Subject: FW: Application_Ref_No=AW/164/20/HH

Subject: Application_Ref_No=AW/164/20/HH

We wish to submit an objection to the planning application above. These are retrospective plans, the first ones Ref: AW/272/19/HH were not adhered to by the builders and a totally different and unacceptable roof was constructed.

Dwg. no.
1921 / 03

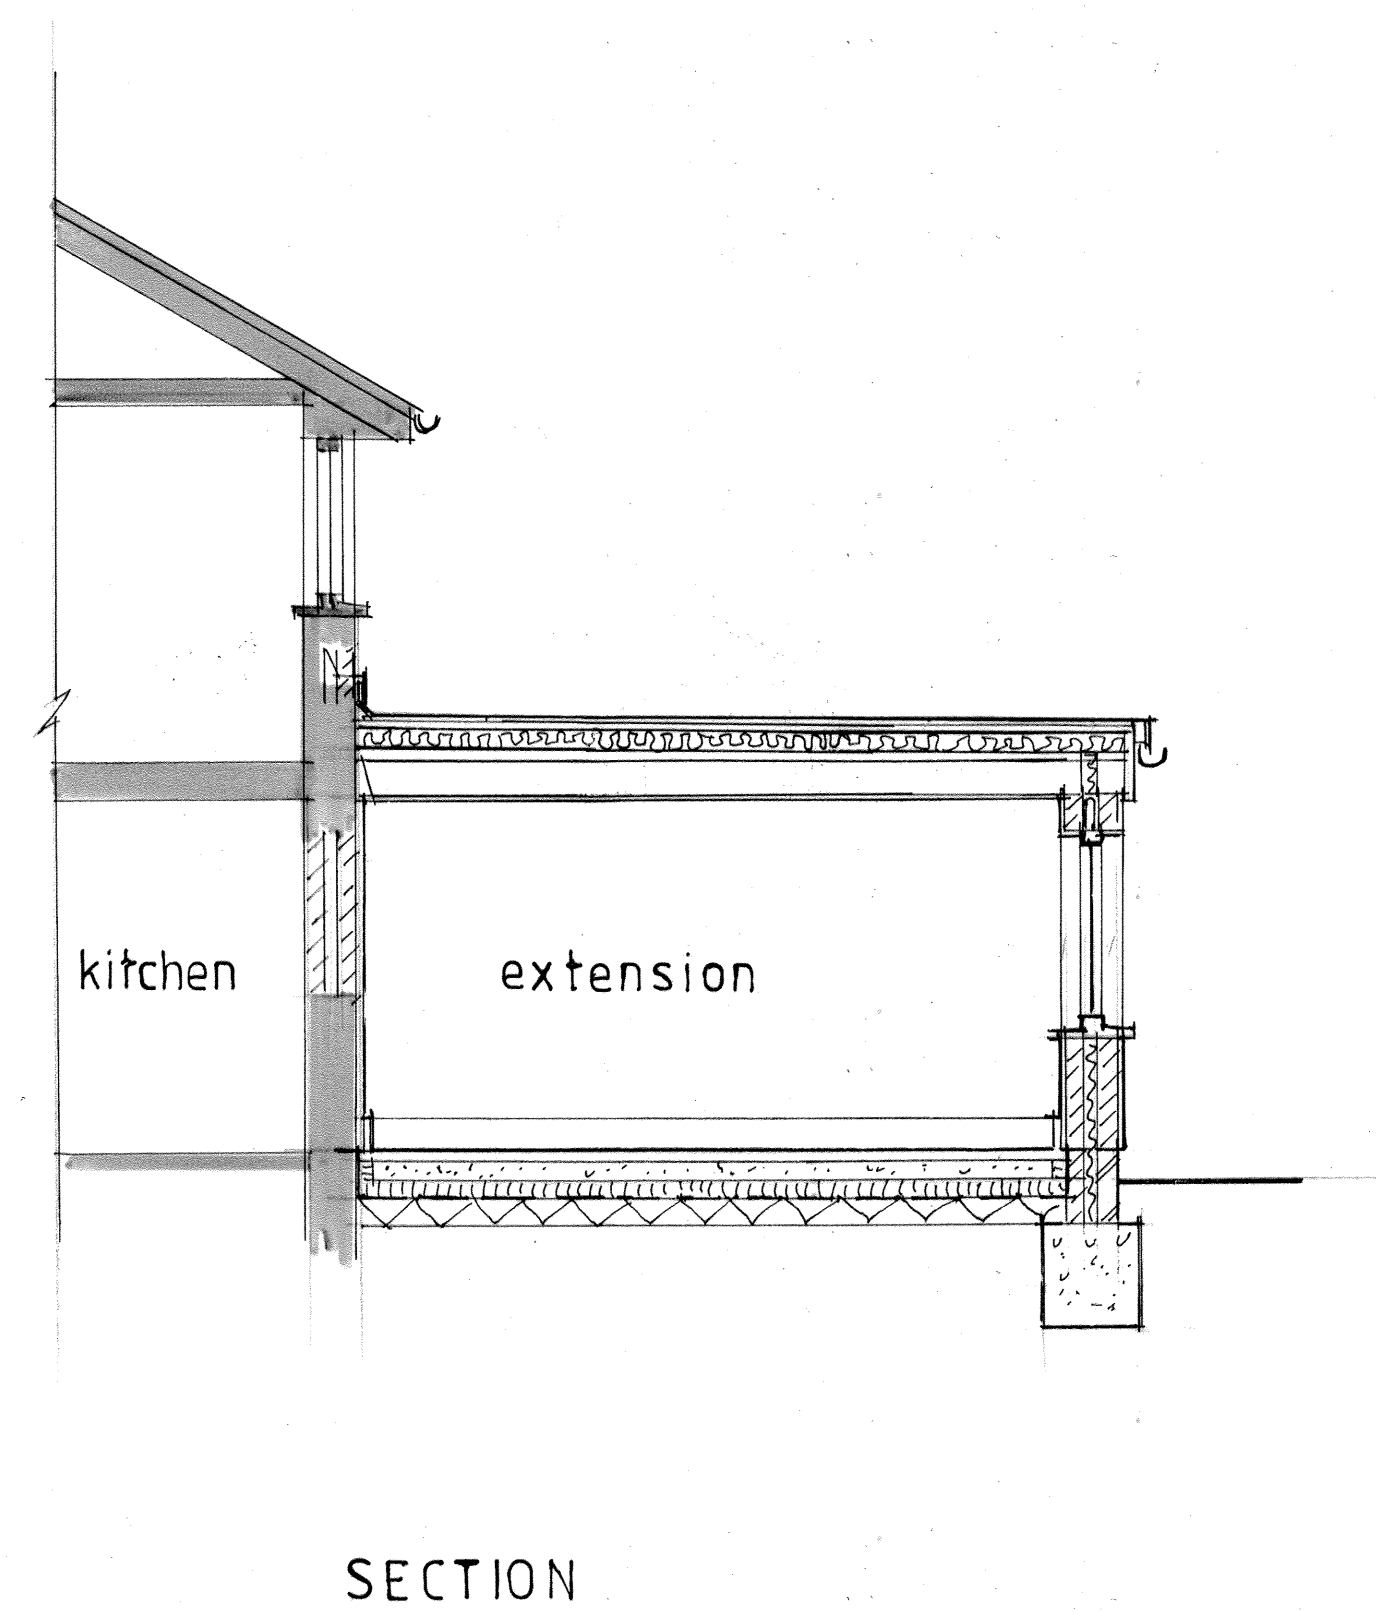
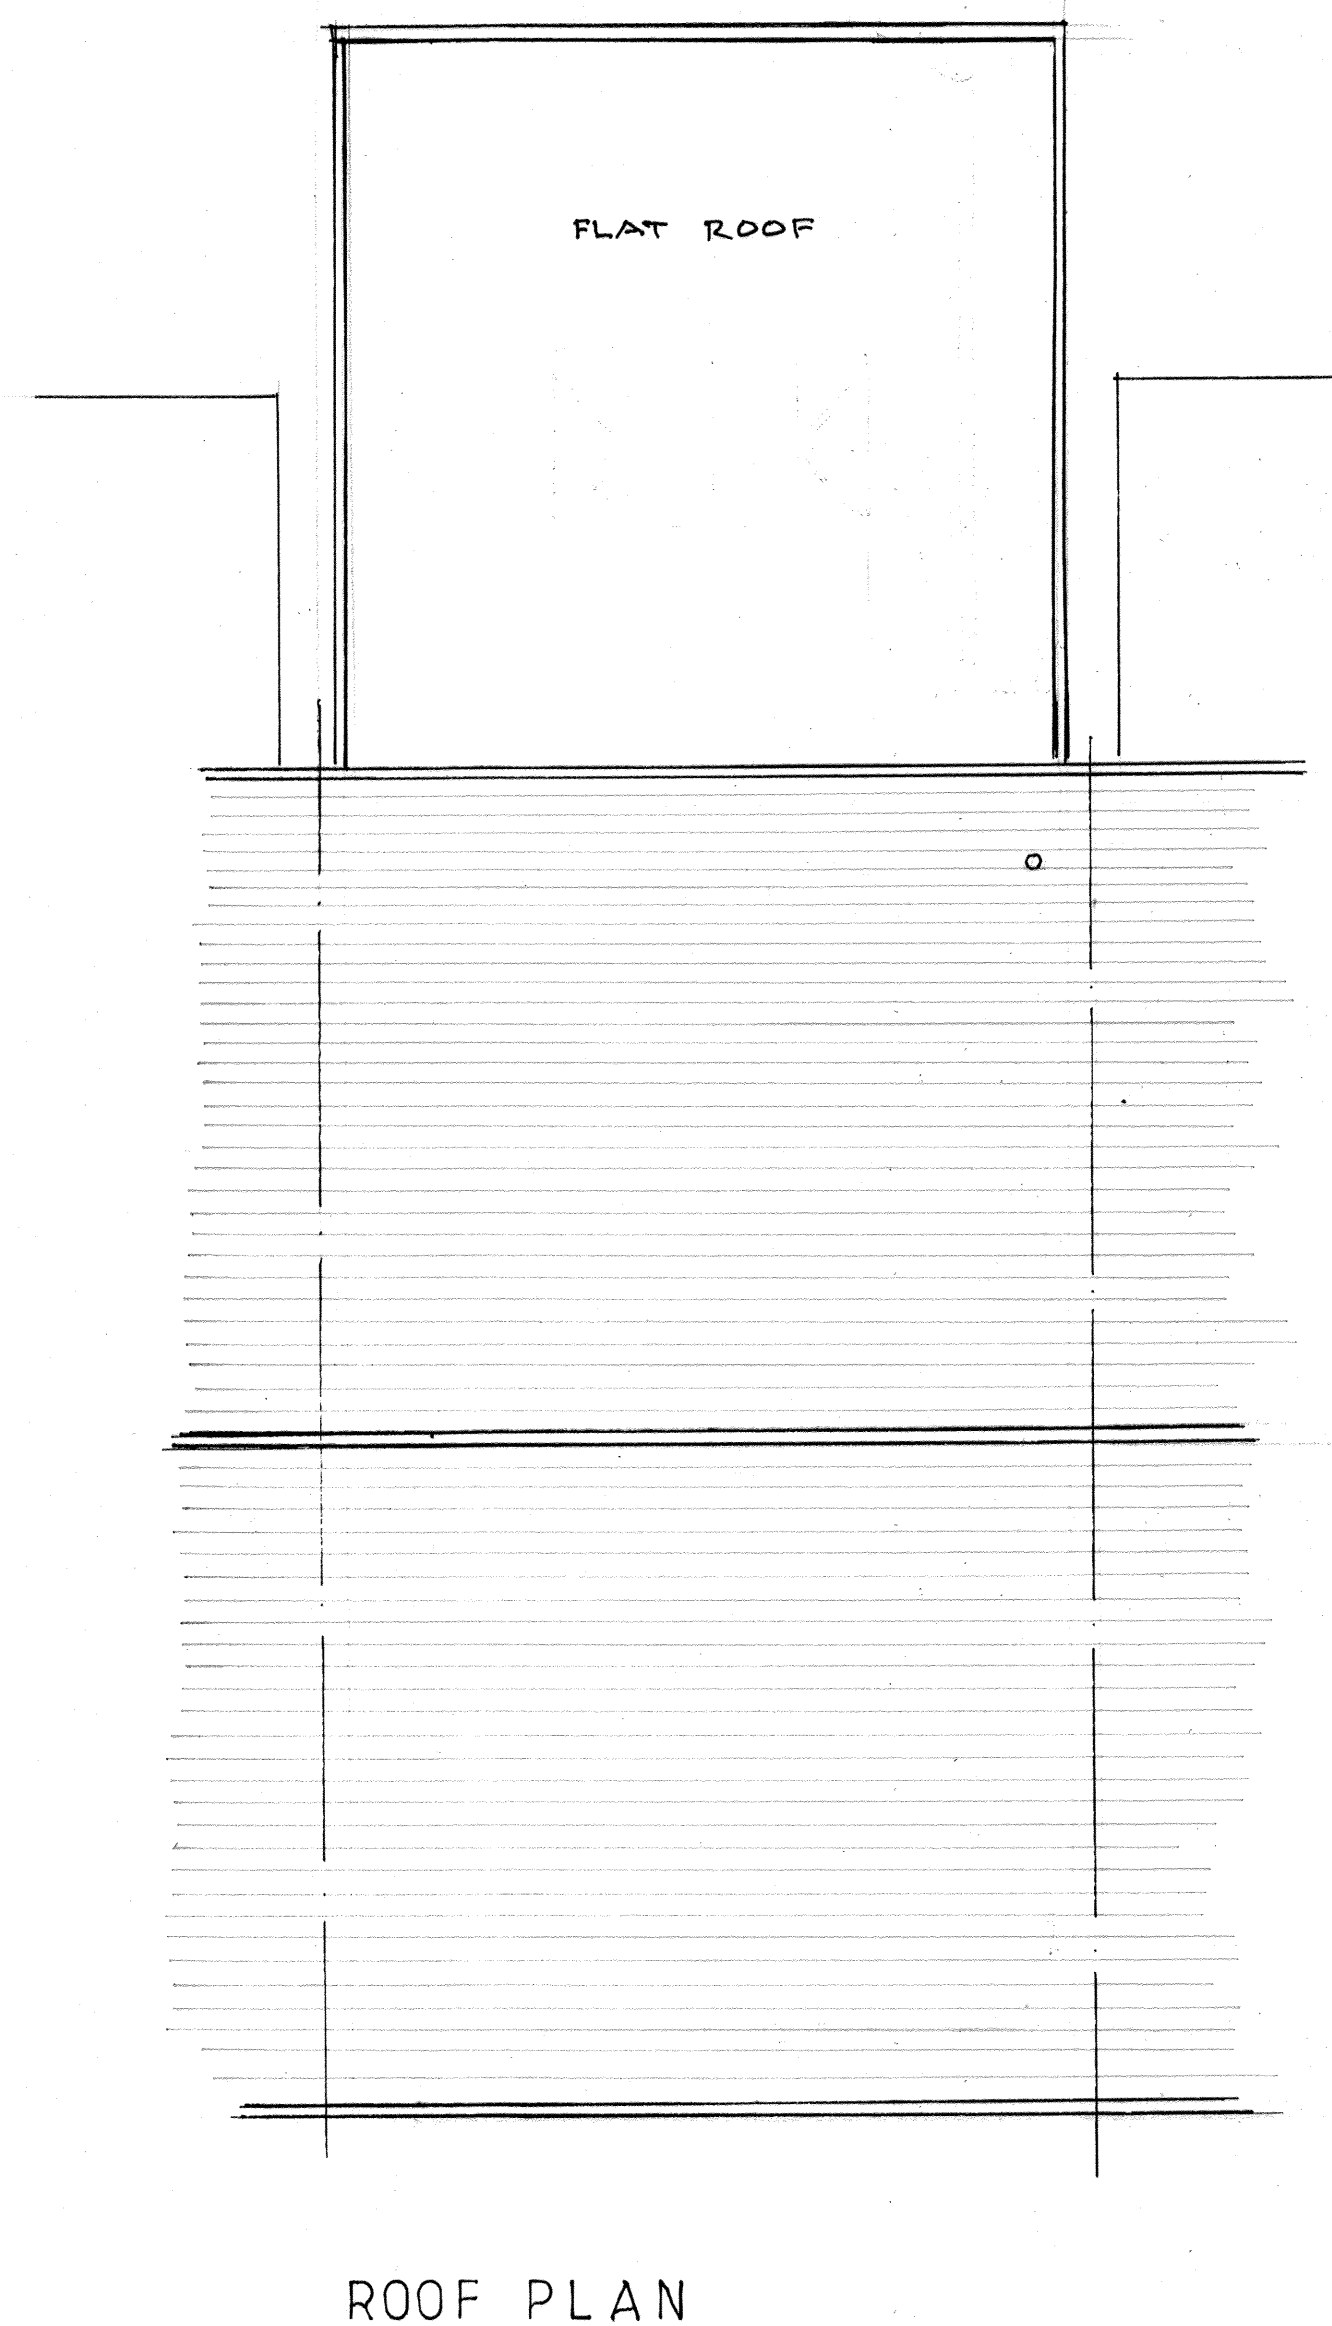
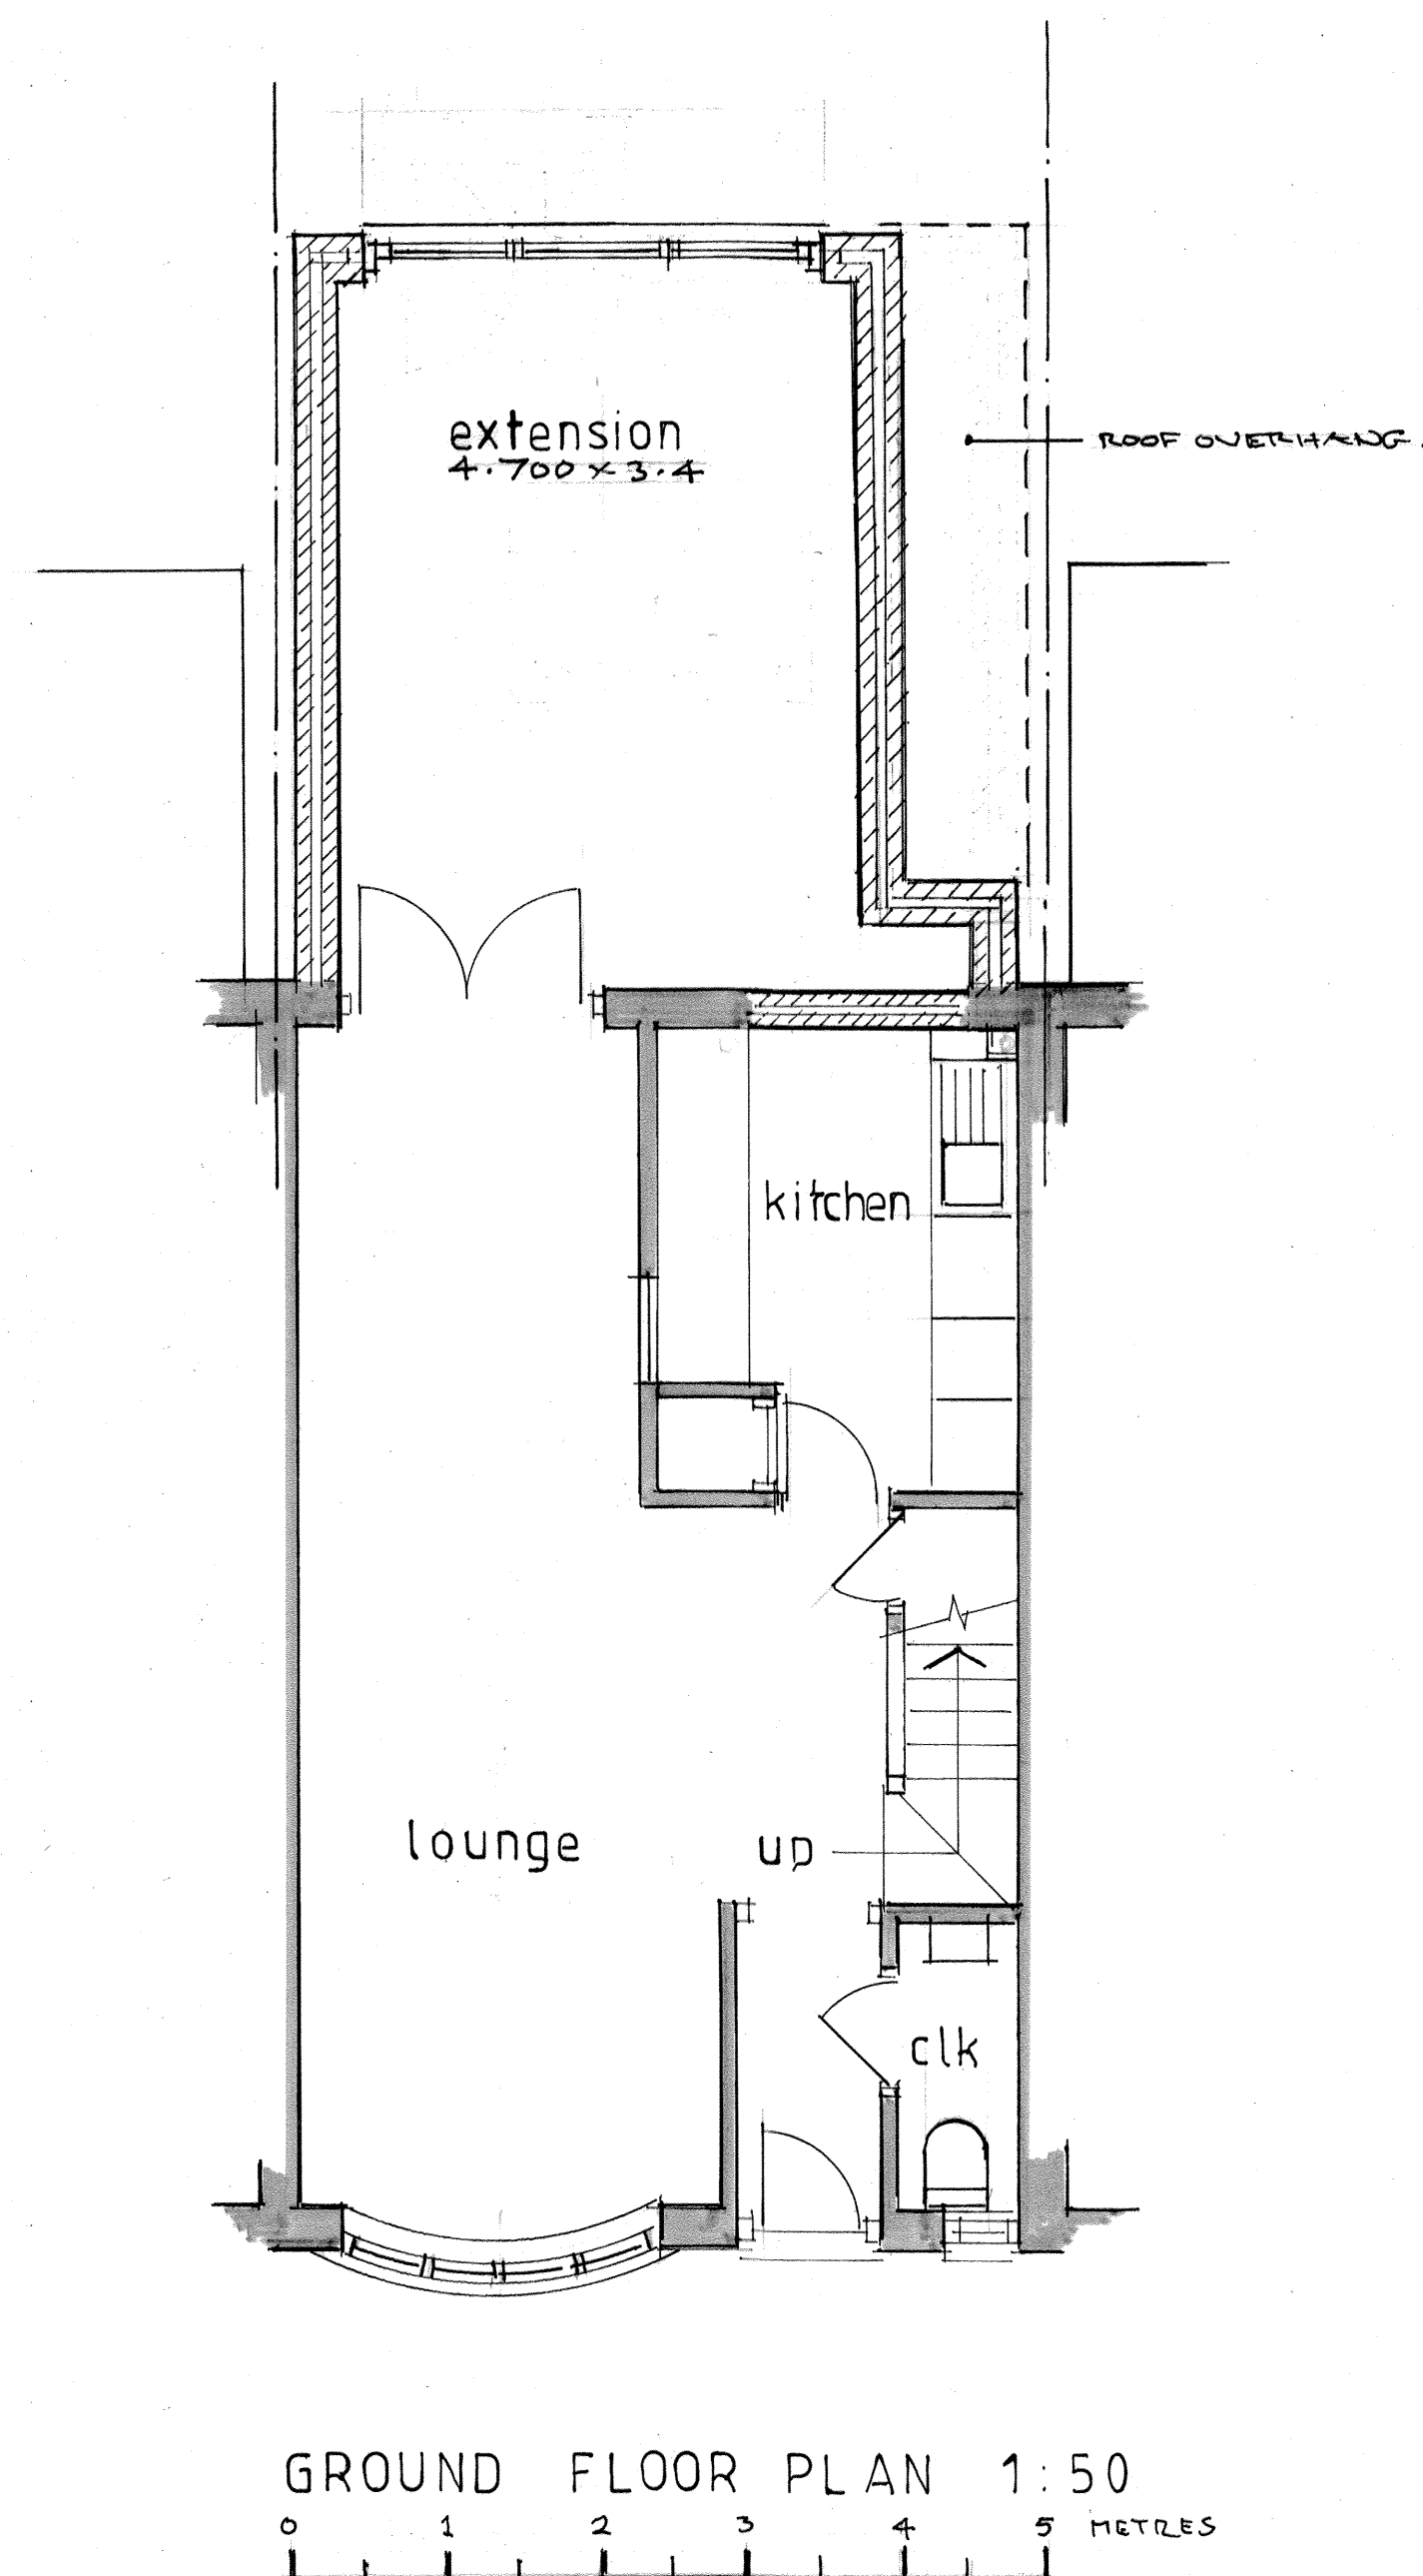
The roof and fascia are too high and not in keeping with the style and character of the existing properties either side.

The width of the roof is in excess of the measurements shown on the plan thus giving no room for maintenance to our property.

The depth of the fascia is in excess of the measurements shown on the plan.

There is an incline to the roof not shown on the plan.

The front soffet is not shown at all on the plan yet it extends 300mm beyond the building line.

There is no evidence on the plan of where the surface water from this vast area of roof will discharge and into what and where.

The new plans are not consistent with the already constructed building and do not represent accurately what has been built..
